Excerpt from LDC regarding alternative landscaping. Please include justification per Sec. 6.2.2(A)(4), which includes analysis of the purpose of landscape section as defined in Sec. 6.2.2(A)(1). Let me know if you have any questions.

Attn: Ryan Howser
Re: Letter of Intent
Eagle Lake Camps Site Development Plan,
6935 Rampart Range Road
Cascade, CO 80809

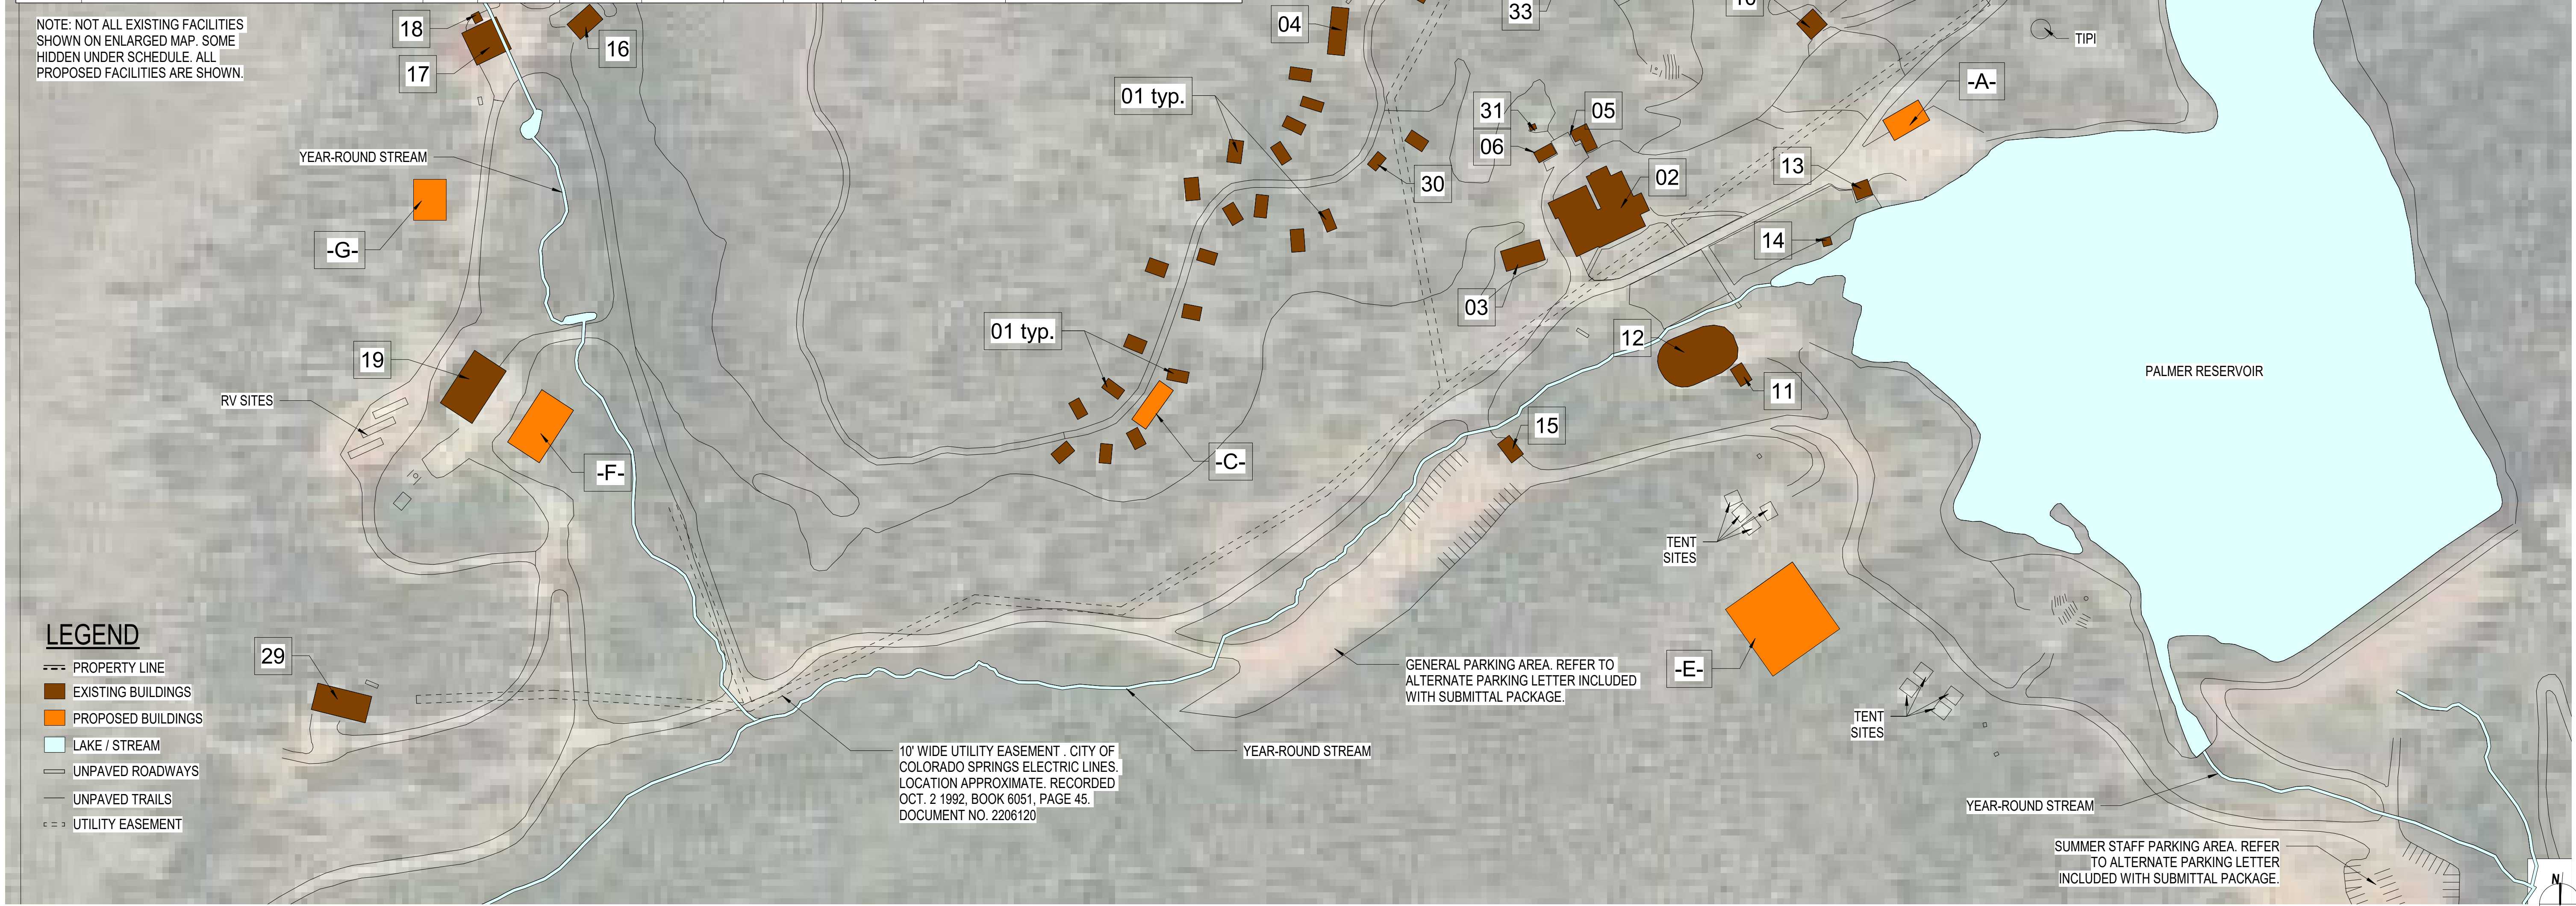
"campground" is not listed use in the parking requirement table. Please specify the number of spaces you have. Justification provided is sufficient for number of parking spaces.

The Eagle Lake Camps property has two maintained dirt parking lots, which are one main parking lot and one summer-staff parking lot. The main parking lot is only used for parent parking during camper drop-off and pick-up on Sunday afternoons and Friday mornings for 10 weeks in the summer. Our drop-off and pick-up times are staggered so that the parking lot and our registration staff are not overwhelmed with families. On the days between camper drop-off and pick-up, there are typically only 5 camp-owned vehicles parked in the main parking lot. The main parking lot does not have more than 25 cars concurrently parked more than 30 days per year. The summer-staff parking lot is used for approximately 40 cars belonging to summer staff. Summer staff are not allowed to drive or park their cars in the main areas of camp while camp is in session.

We are requesting relief from the paving requirement for parking lots larger than 25 spaces for the following reasons:

- Paved parking lots are not in harmony with the surrounding area. (The nearest paved road is more than three miles away, at Rampart Reservoir.)
- The current parking lots consist of dirt, road base, and vegetation, which are all permeable surfaces. Paving the two parking lots would likely create additional stormwater drainage challenges.
- The main parking lot is used less than 30 days of the year and the staff parking lot is used for 10 weeks of the year.
- The property is located at 9500 feet of elevation and is exposed to much harsher winter weather conditions than Colorado Springs. Paved parking lots in that environment will require considerable annual maintenance. The costs to build and maintain two parking lots in that environment will present undue financial and labor burdens.
